Re: Mesa del Sol Montage Unit 4 (Project # PR-2020-003422, Application # SD-2020-00091,
Hydrology File R16D006A), Comment Response Letter

Enclosed are the responses to the comments provided on the June 17, 2020 DRB hearing.
Comments and responses are listed below by department.

TURNING MOVEMENT MONTAGE UNIT 4

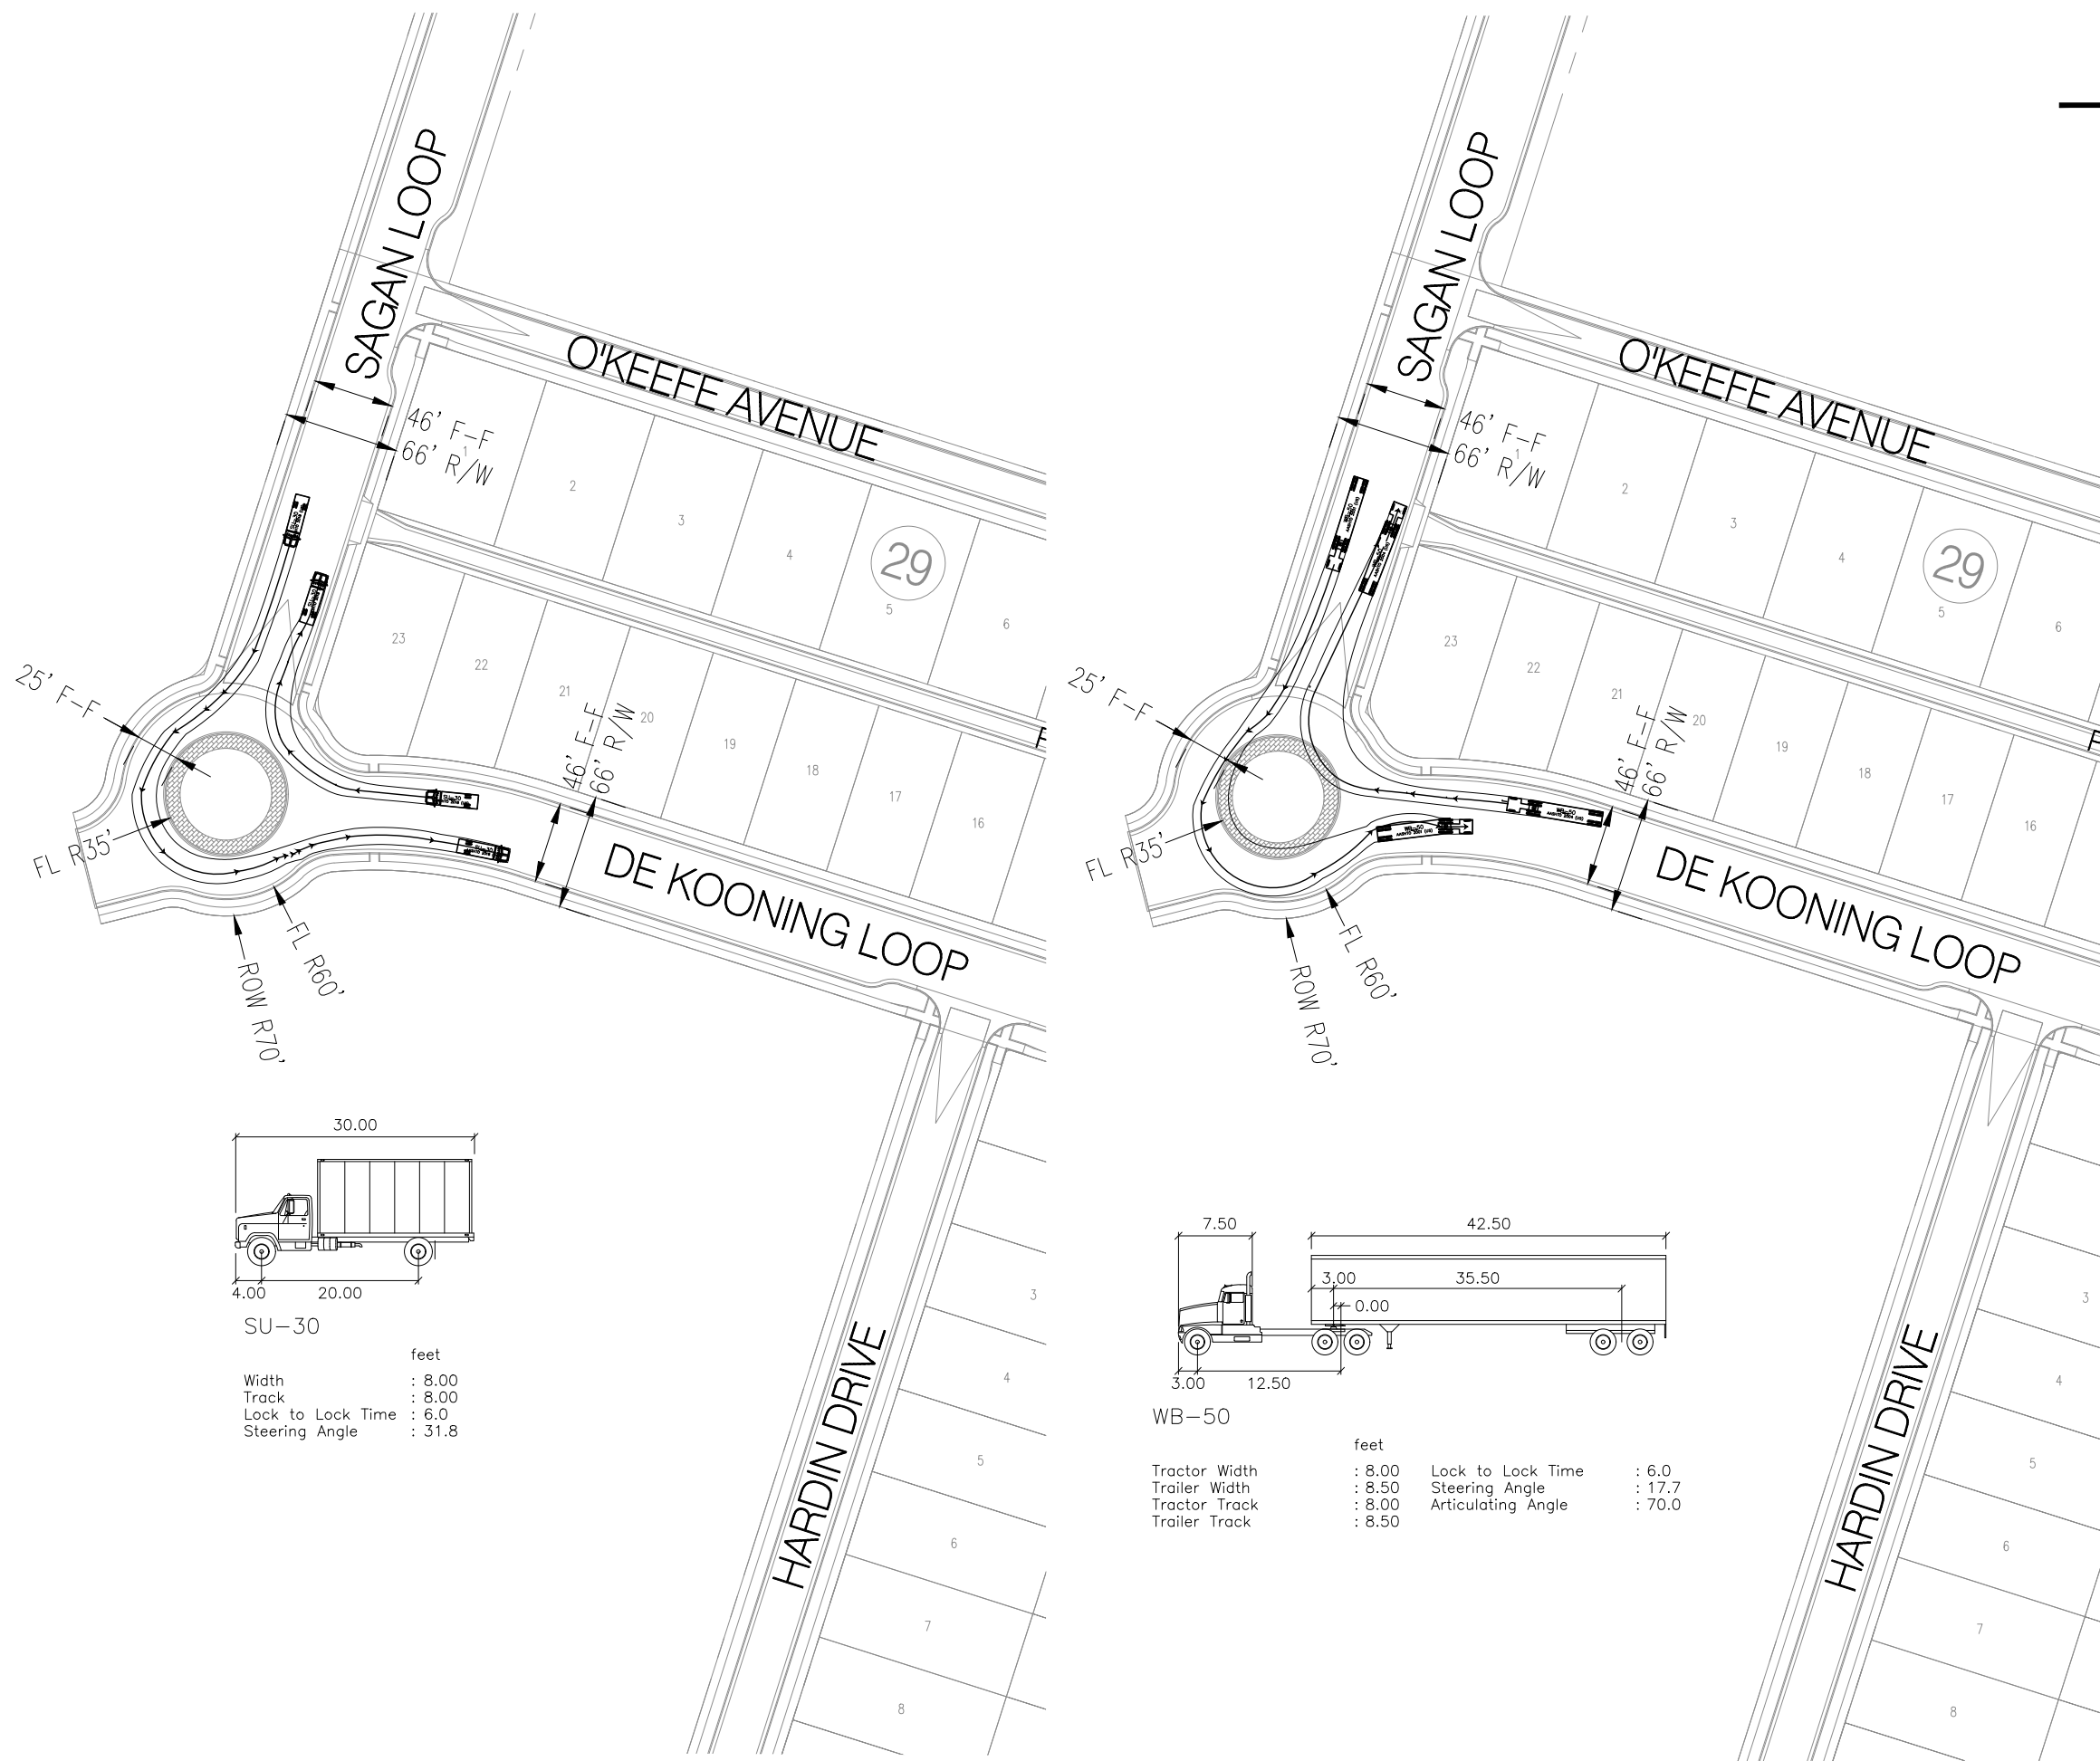
4. Provide a road cross-section of the traffic circle.
Response: The traffic circle will be detailed in the construction drawings with point tables and spot elevations. For information on the Overall Paving Plan, radii, F-F dimensions, and signage was added to define the traffic circle. In addition, the turning movements for the design vehicle SU-30, and larger WB-50 vehicle is shown in the attached Turning Movements Exhibit. The WB 50 vehicle will need to use the truck apron to complete the turn. The truck apron will be designed with a mountable curb to facilitate this movement. Please see attached Revised Paving Plan and the attached Turning Movements Exhibit.

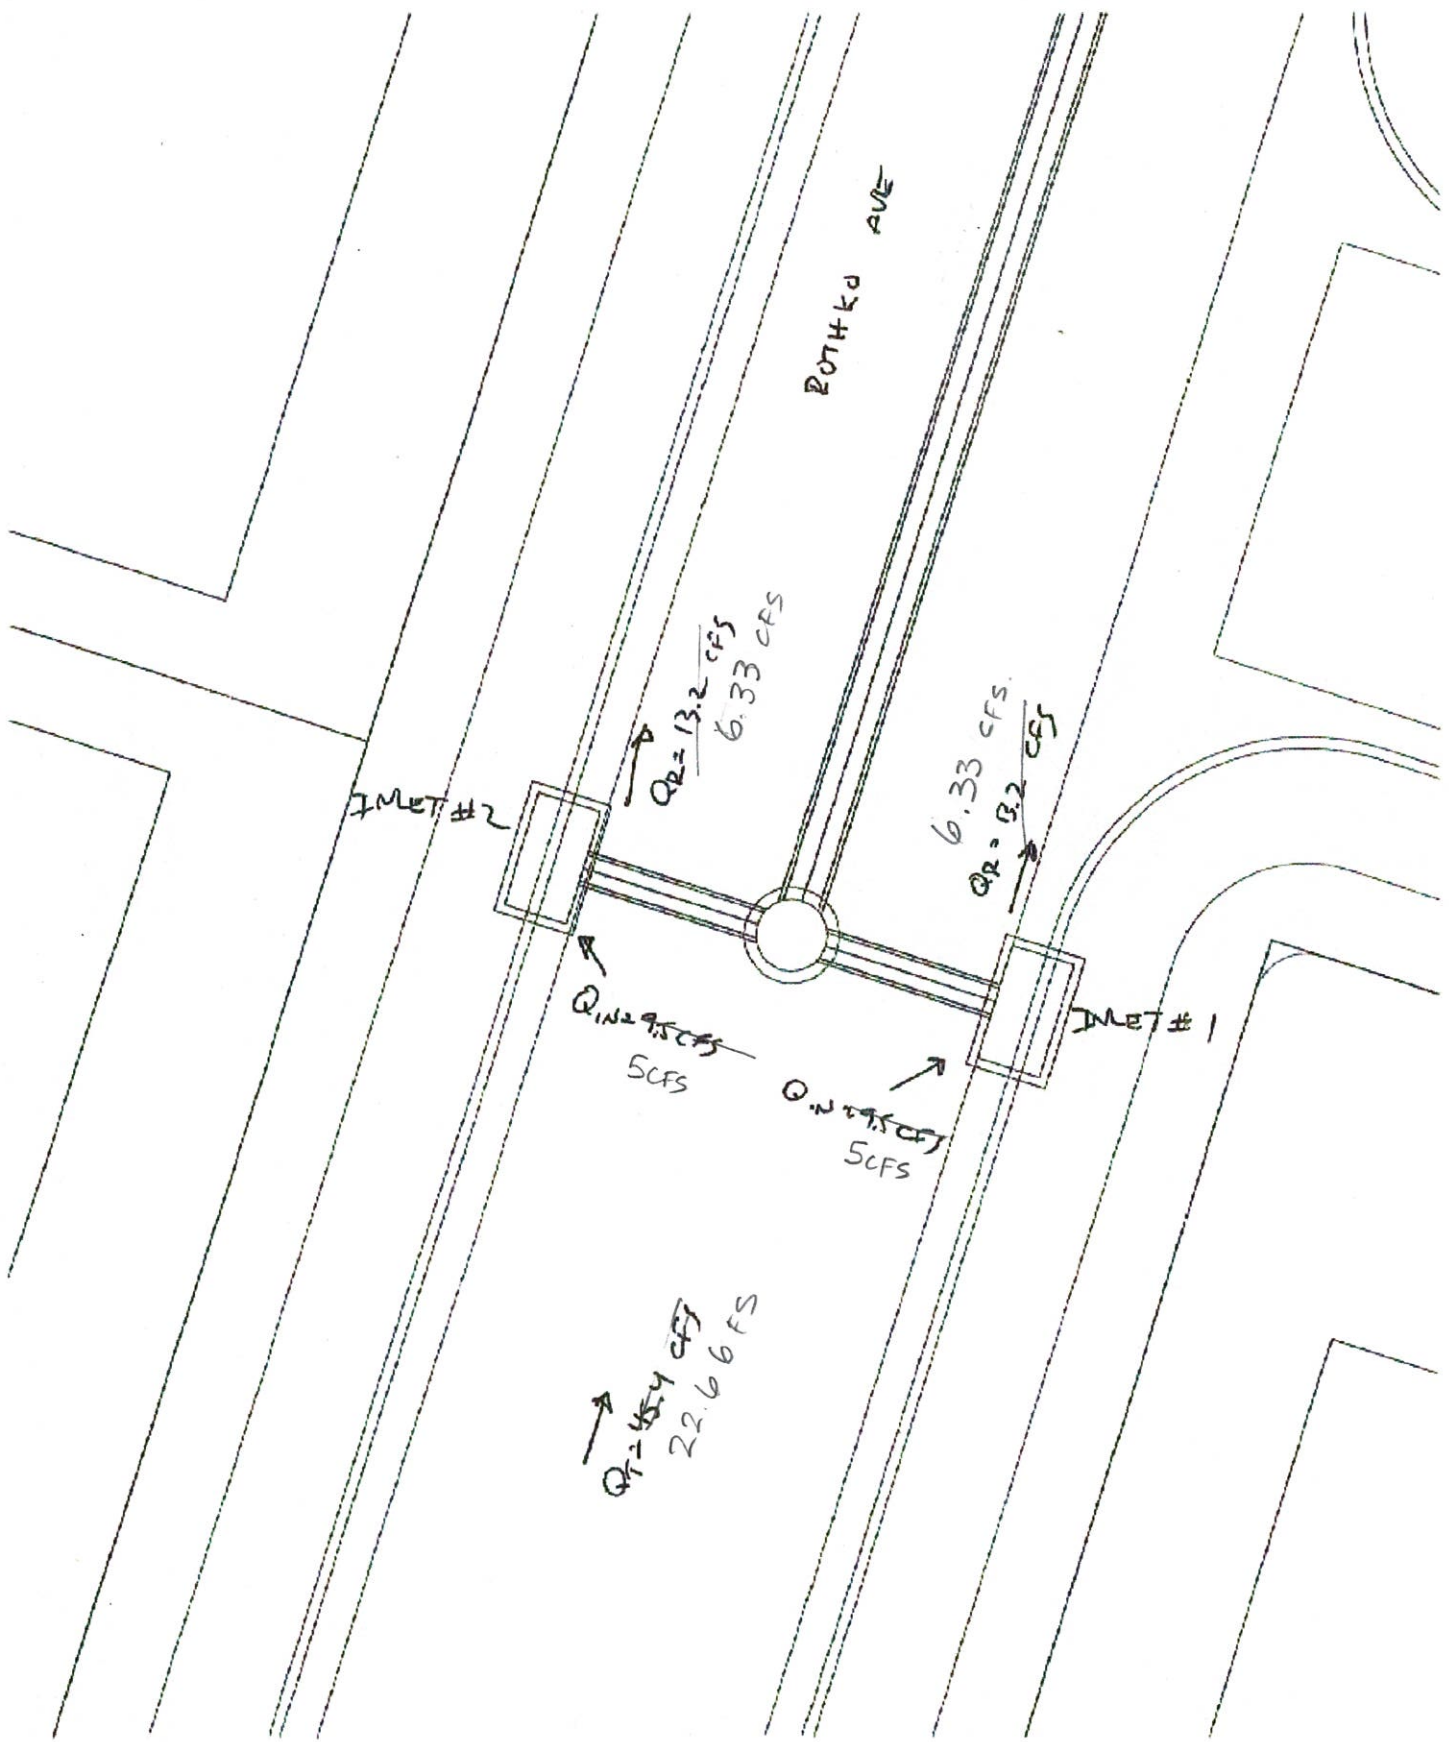
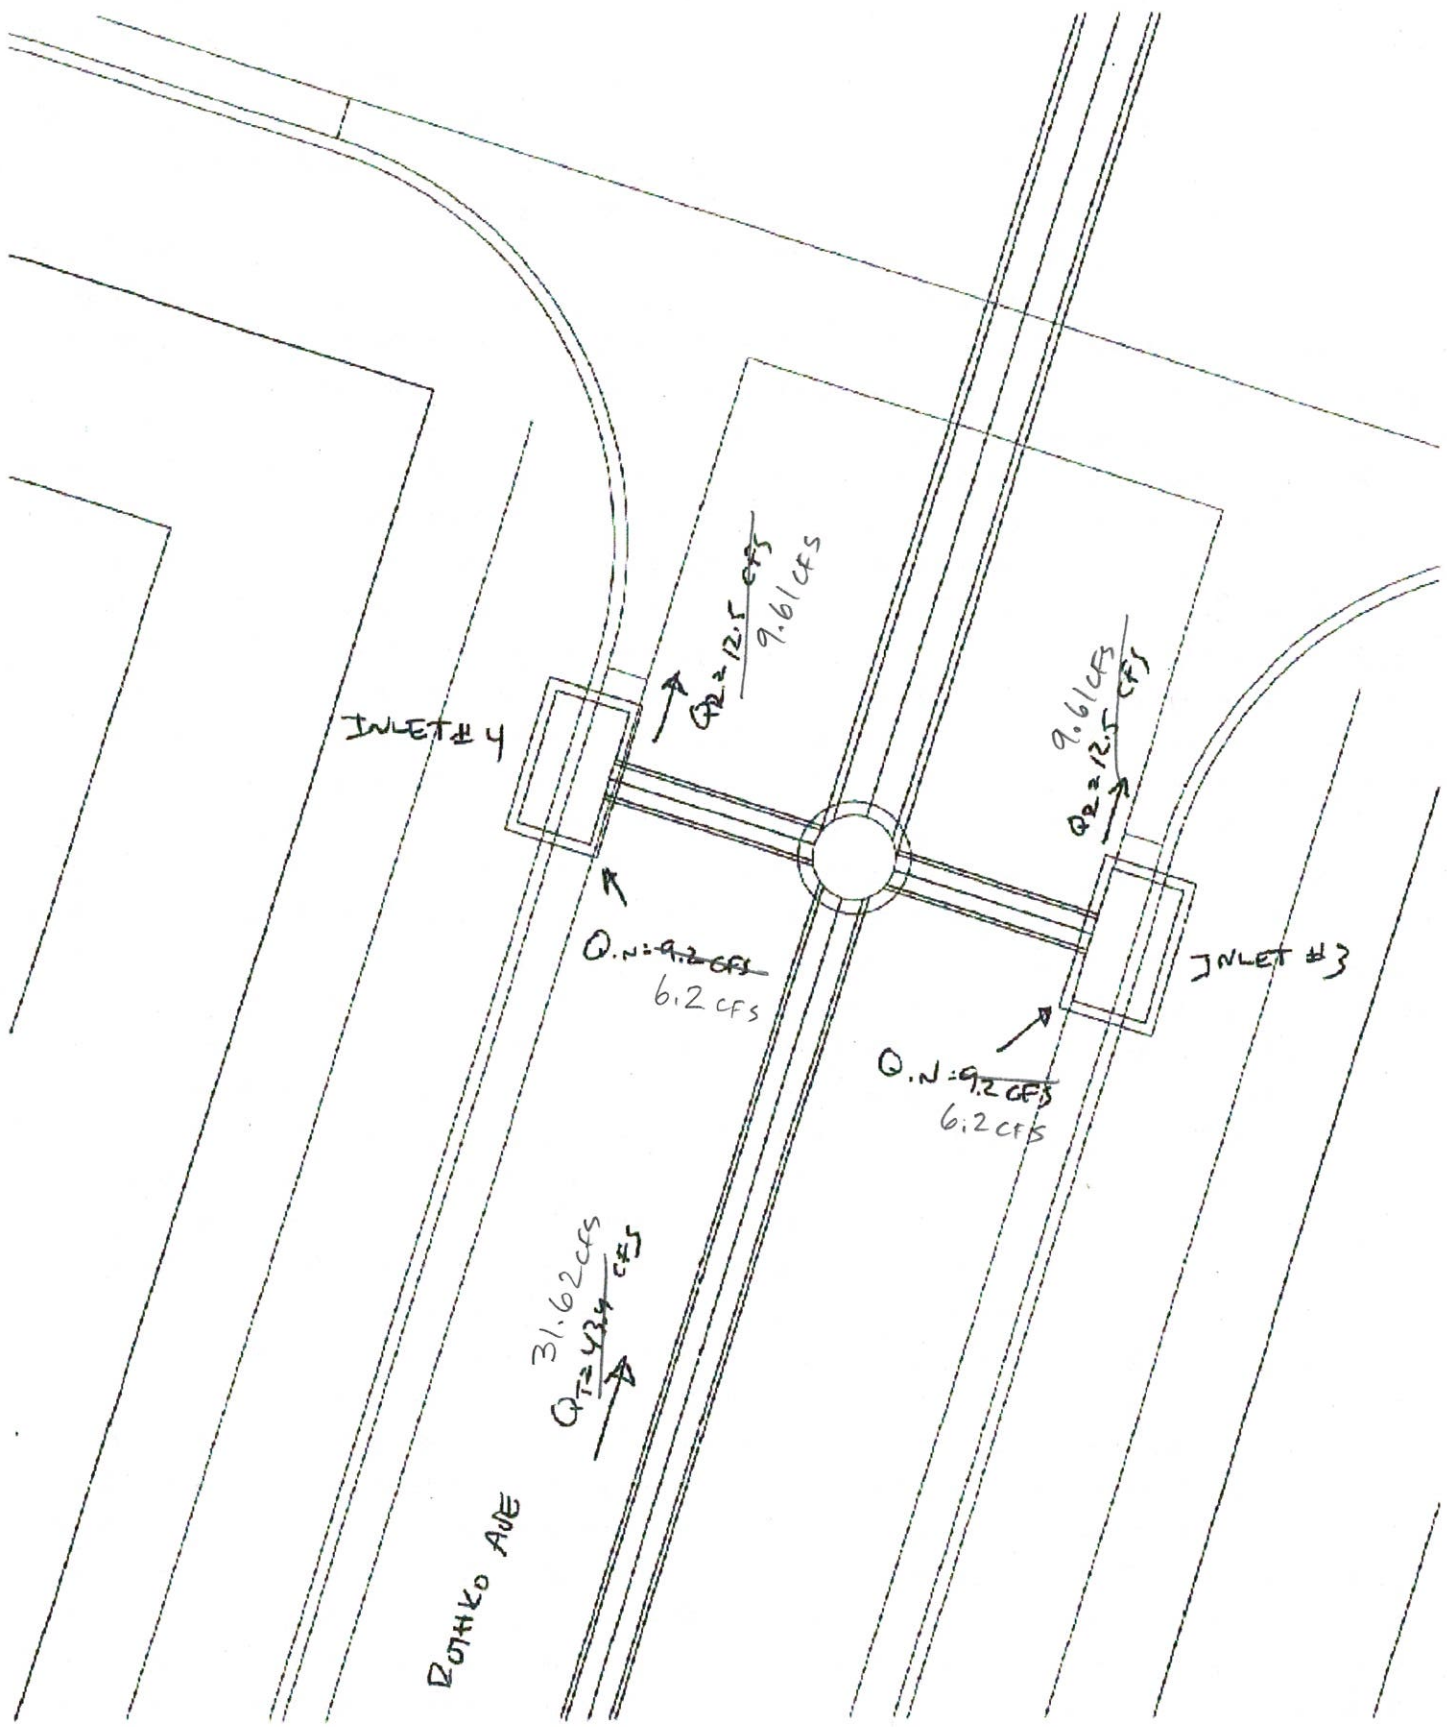
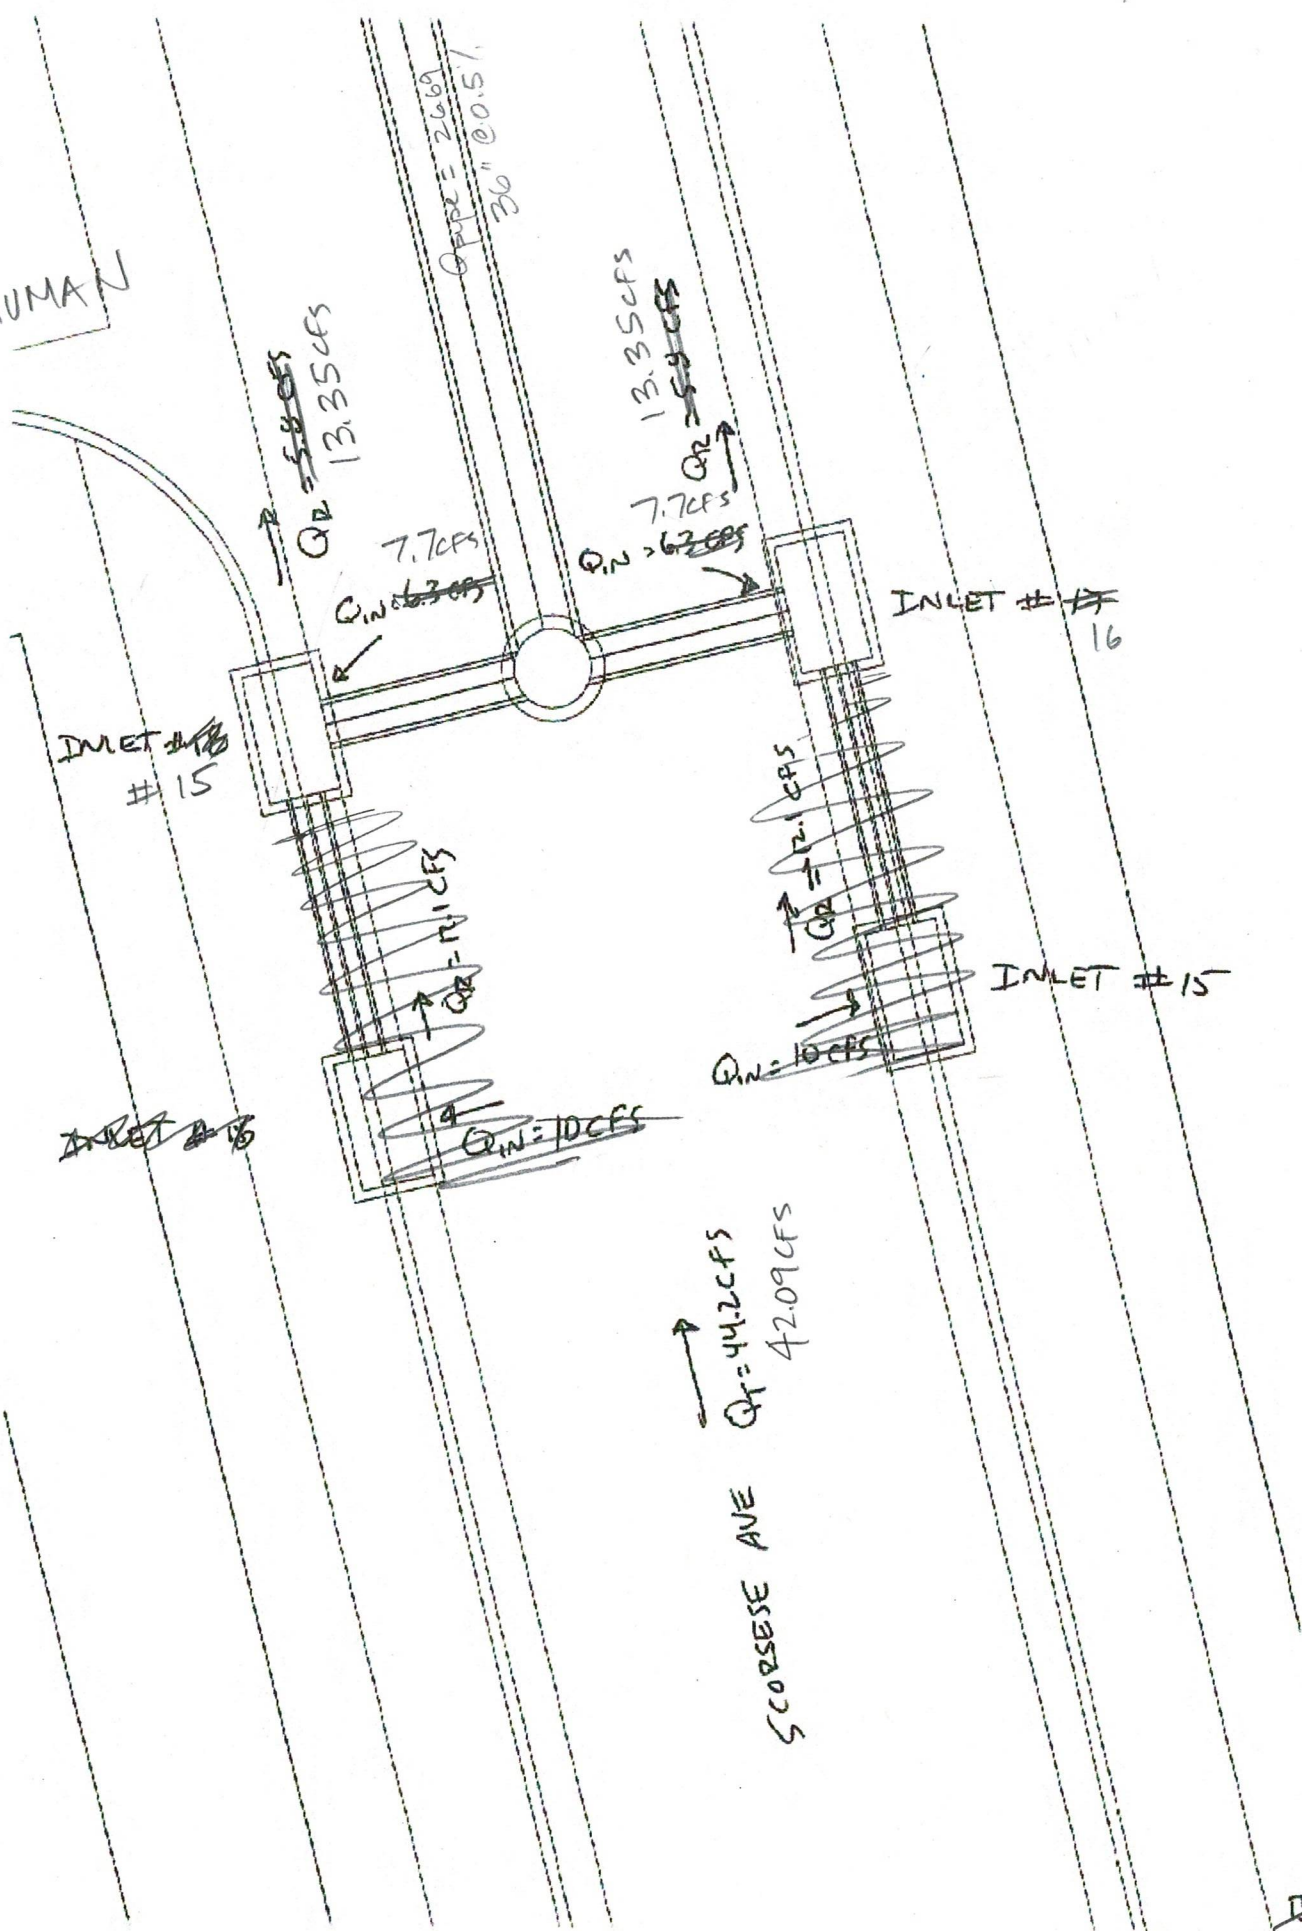
1. An approved grading plan and drainage report is required.
Response: A revised grading and drainage is submitted concurrently to this submittal.
2. In the Amended Drainage Report on pages 30,32 and 36 for inlets on Dekooning and Sagan, please size/type of inlet being analyzed. All previous sections listed this information,
Response: Completed. See attached Revised Drainage Report
